# Lower Thames Crossing

## 9.181 Draft Statement of Common Ground between (1) National Highways and (2) Stuart Mee & Family

**DATE: November 2023**  
**DEADLINE: 7**

Planning Inspectorate Scheme Ref: TR010032  
Examination Document Ref: TR010032/EXAM/9.181

PLAN 1

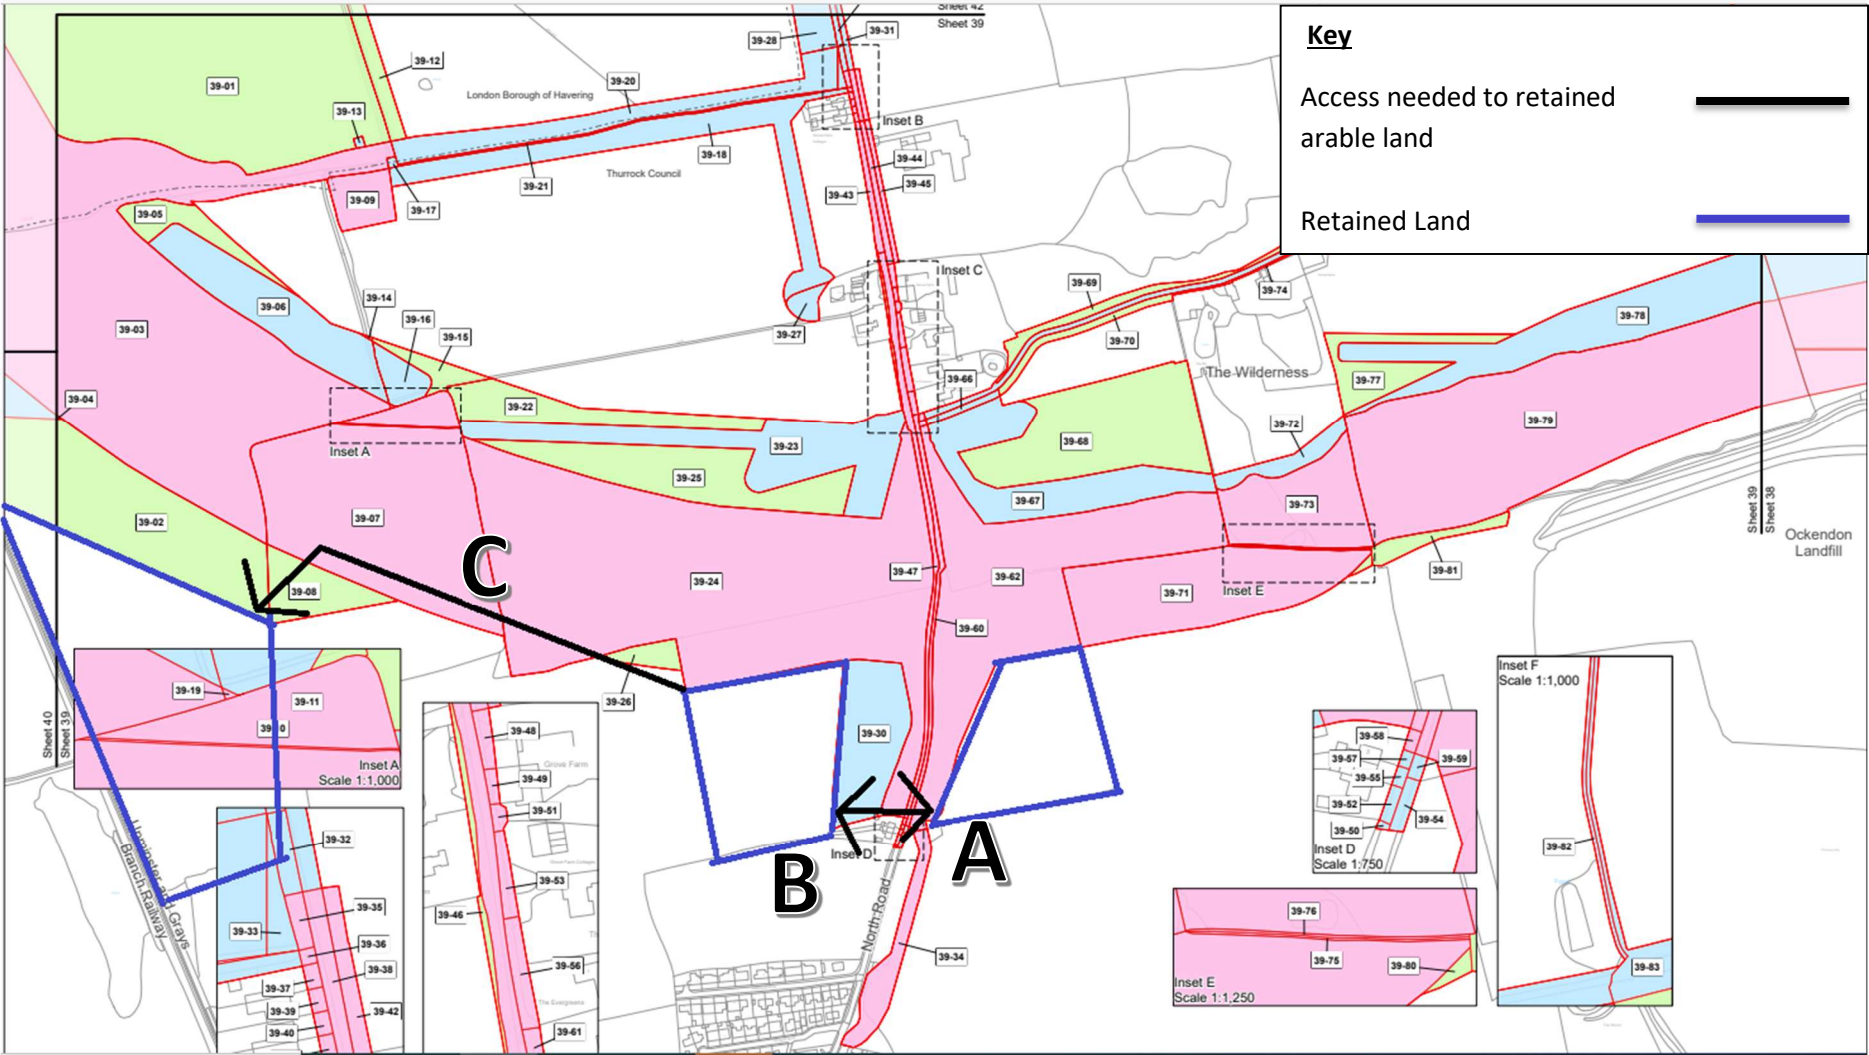
Topic	Item number	Stuart Mee & Family comment (Landowner)	The Applicant's response	Document Reference	Status
		<p>from the reservoir out around the fields both east and west of M25 / LTC alignment. The irrigation line where it crosses the M25 is illustrated in Plan 1</p> <p>The Landowner has commissioned a specialist water consultant to appraise the predicted impact and possible solutions to provide a viable and suitable alternative system.</p> <p>Understanding what the Applicant is proposing is a specialist piece of work and therefore they need their own Expert in this area. An options report has been sent to the applicant for review and the landowner requests feedback before Deadline 5.</p> <p>The Landowner is encouraged that both parties are finding a solution however, there is concern that there is an unknown on the water flow and levels as a result of the construction of LTC and the Landowner therefore reserves the right for compensation.</p> <p>The Landowner needs this to form part of a protective provision or side legal agreement.</p>	<p>monitoring equipment was installed in December 2022 along with an associated rain gauge.</p> <p>The landowner's consultant has provided an Options Report to the Applicant on 20 July 2023 which is being reviewed. This will then help to inform a Preferred Option Development Report due autumn 2023.</p> <p>In principle, the Applicant is happy to enter into a legal side agreement regarding this matter. Such agreement will either be to an agreed design if available or to an approach to progress negotiations to agree a design.</p>

PLAN 2

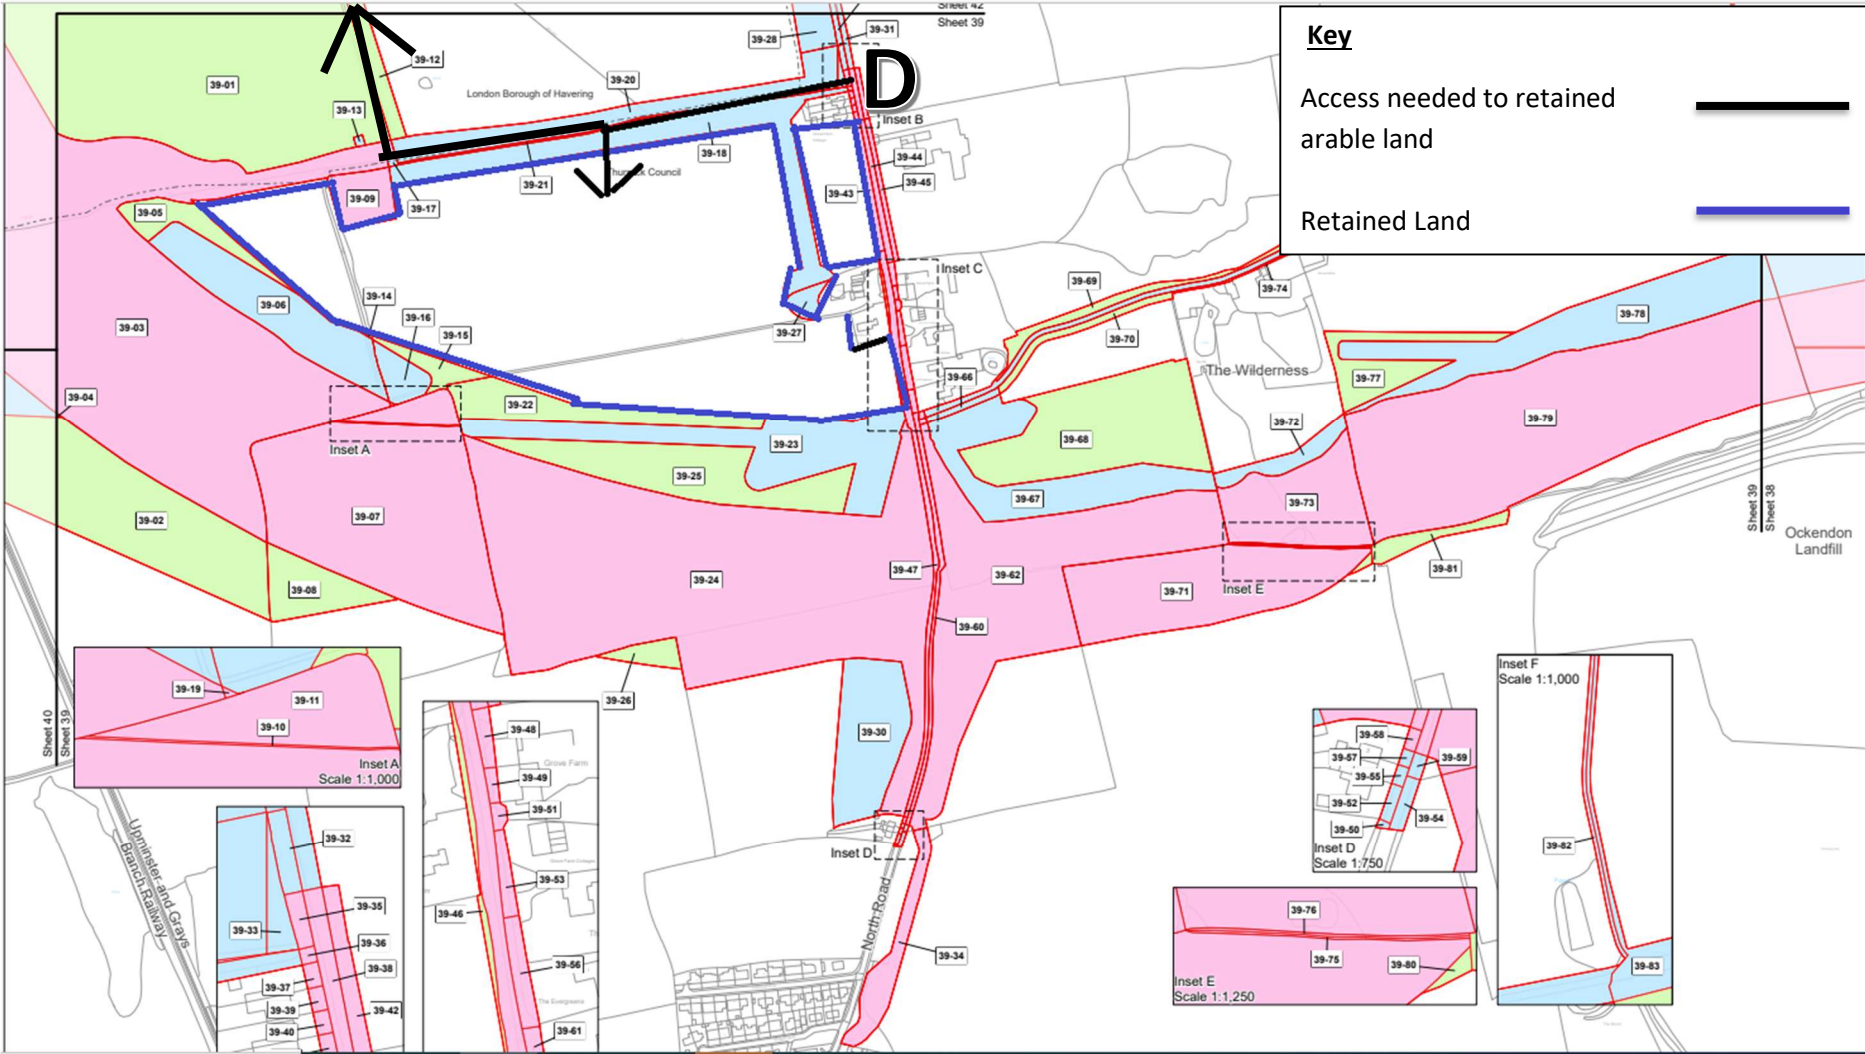
Topic	Item number	Stuart Mee & Family comment (Landowner)	The Applicant’s response	Document Reference	Status
		If the Landowner does not receive a legal agreement then the landlord maintains a fundamental objection to the point.			
<b>Grove Farm Track</b>  <b>(Plot 39-65 and Plan 2 below)</b>	2.1.4	<p>Concerns as to the availability of the farm track use to Landowner during construction; nature and intensity of the Applicant’s use.</p> <p>For context, the road is used by the farm, two houses and three businesses. It is a single-track road with infrequent passing bays. Access is identified by black arrows into fields edged purple on the Plans 11 below in 2.2 Notes.</p> <p>Security is a real concern and ensuring that there is no unauthorised users needs to be carefully considered by the Applicant.</p> <p>An email from Richard Saville to Stuart Mee dated 08/03/2022 assists but fails to provide specific detail and the landowner will require this to be included in protective provision.</p> <p>The Landowner does not want this to be left until detail design.</p>	<p>The Applicant’s detailed response of 08 March 2022 is summarised as follows:</p> <p><i>“This access road is proposed as a ‘secondary route’ which can be used by HGV construction traffic throughout construction but far less frequently than other routes.</i></p> <p><i>The current programme indicates that compound CA13 will be constructed <u>after</u> the haul road from Medebridge Road has been completed. This means the use of this track for construction works should be minimized, although this cannot be guaranteed until the detailed design stage.</i></p> <p><i>The Applicant will need to undertake some minor utilities works along the track but this would be for a period of weeks rather than months.”</i></p> <p>See also SACR-005 in the Stakeholder Actions and Commitments Register relating to farm access provisions during construction.</p>	<p>Stakeholder Actions and Commitments Register [<a href="#">REP6-050</a>]</p> <p>Outline Traffic Management Plan for Construction [<a href="#">REP6-048</a>]</p>	<p>Matter Under Discussion</p> <p><i>Pending detailed design and Traffic Management Plan</i></p>

PLAN 9

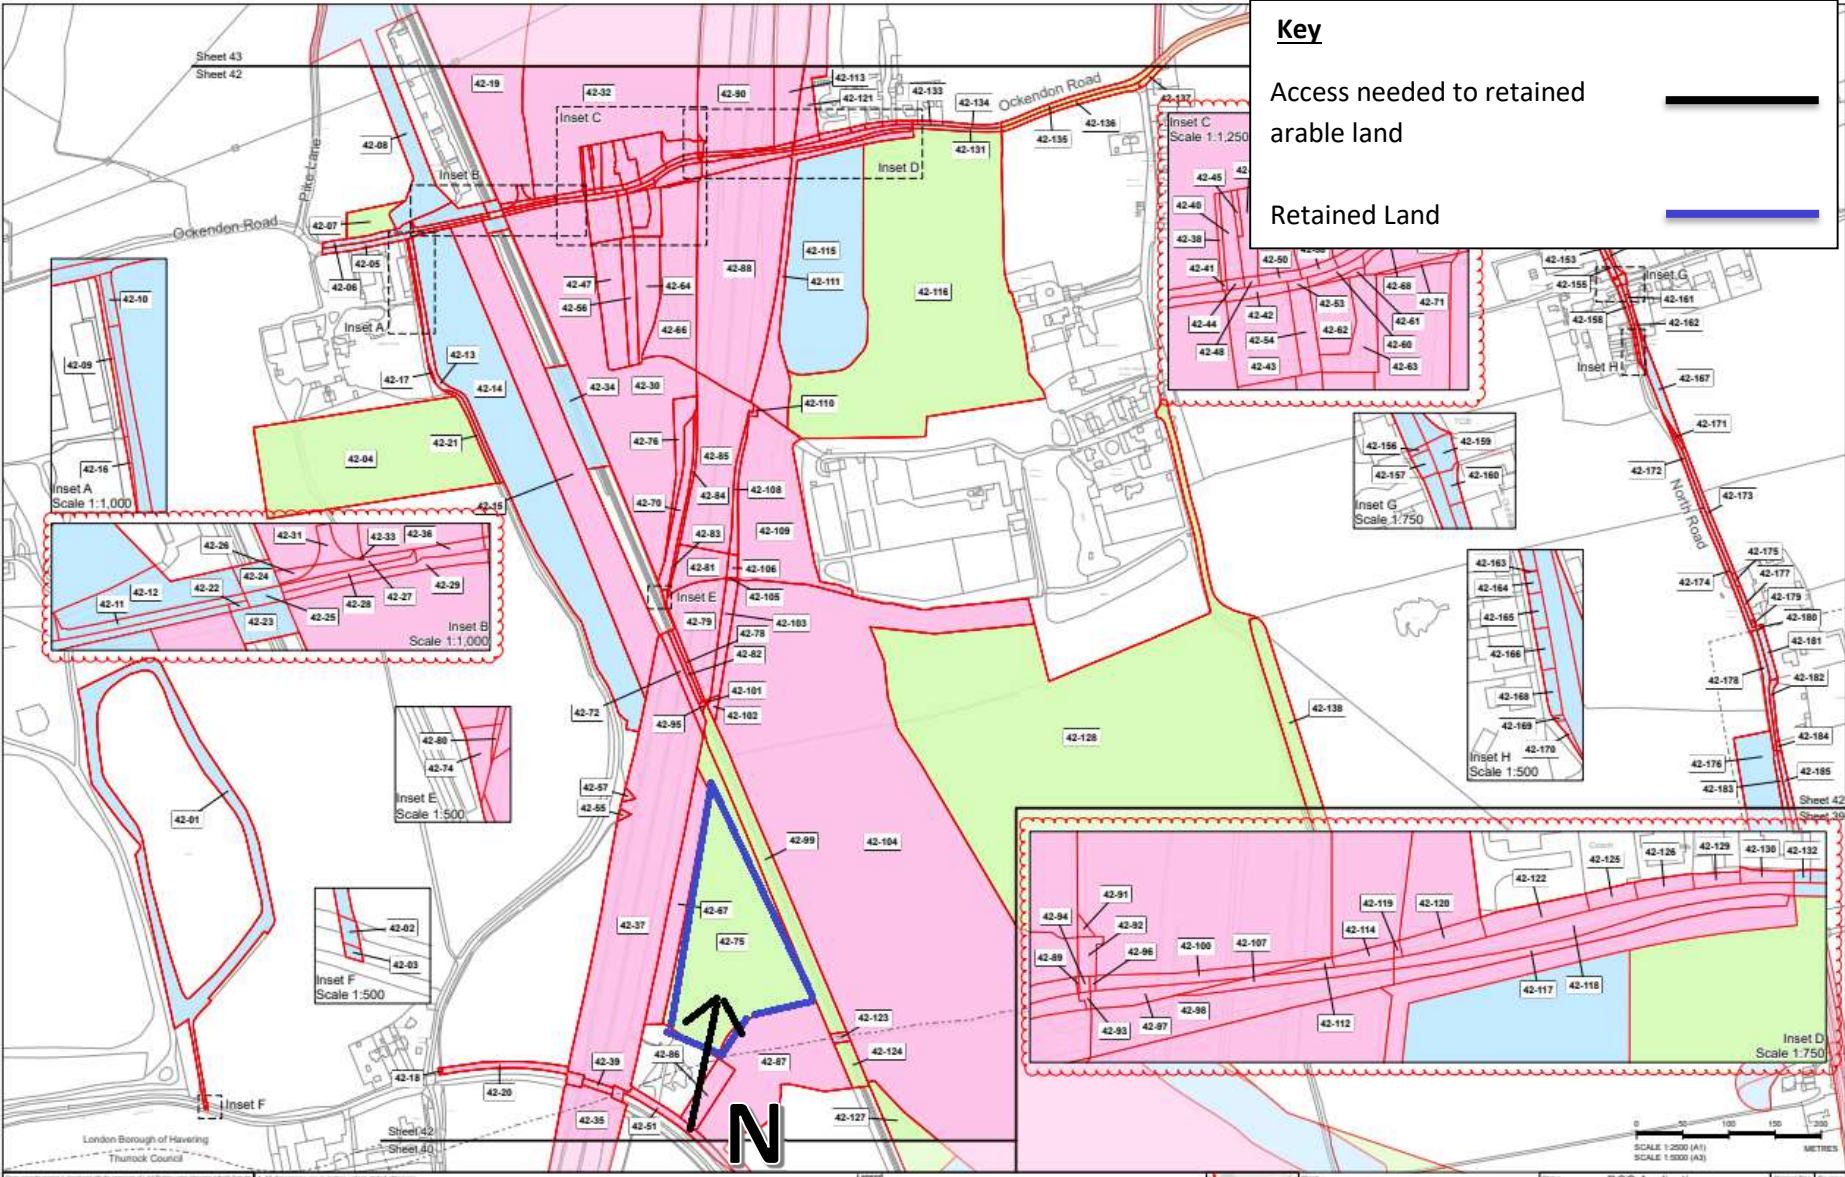
<p><b>Access off Ockendon Road north across Plot 42-19 &amp; Plot 43-04</b></p>	<p>2.1.2</p>	<p>No detail has been provided around the field accesses indicated by black arrows into fields and pond edged purple on Plan 9 below in 2.2 Notes are of concern to the Landowner.</p> <p>The Contractors and National Highways (NH) requires a point of access from Ockendon Road which is to allow continued access for farm vehicles and machinery e.g. combine and tractor and trailers to replace the access lost as a result of the</p>	<p>The Applicant has discussed the request with Forestry England (FE) which is considering the request. The prior agreement of FE would be required as access would be over 'replacement open space' land which must be provided free of encumbrances (see also item 2.1.13 'Replacement Open Space' below).</p> <p>Consequently, a legally binding commitment is not possible at this</p>	<p>N/A</p>	<p>Matter Under Discussion</p> <p><i>(The Applicant to continue negotiations with Forestry England and landowner.)</i></p>
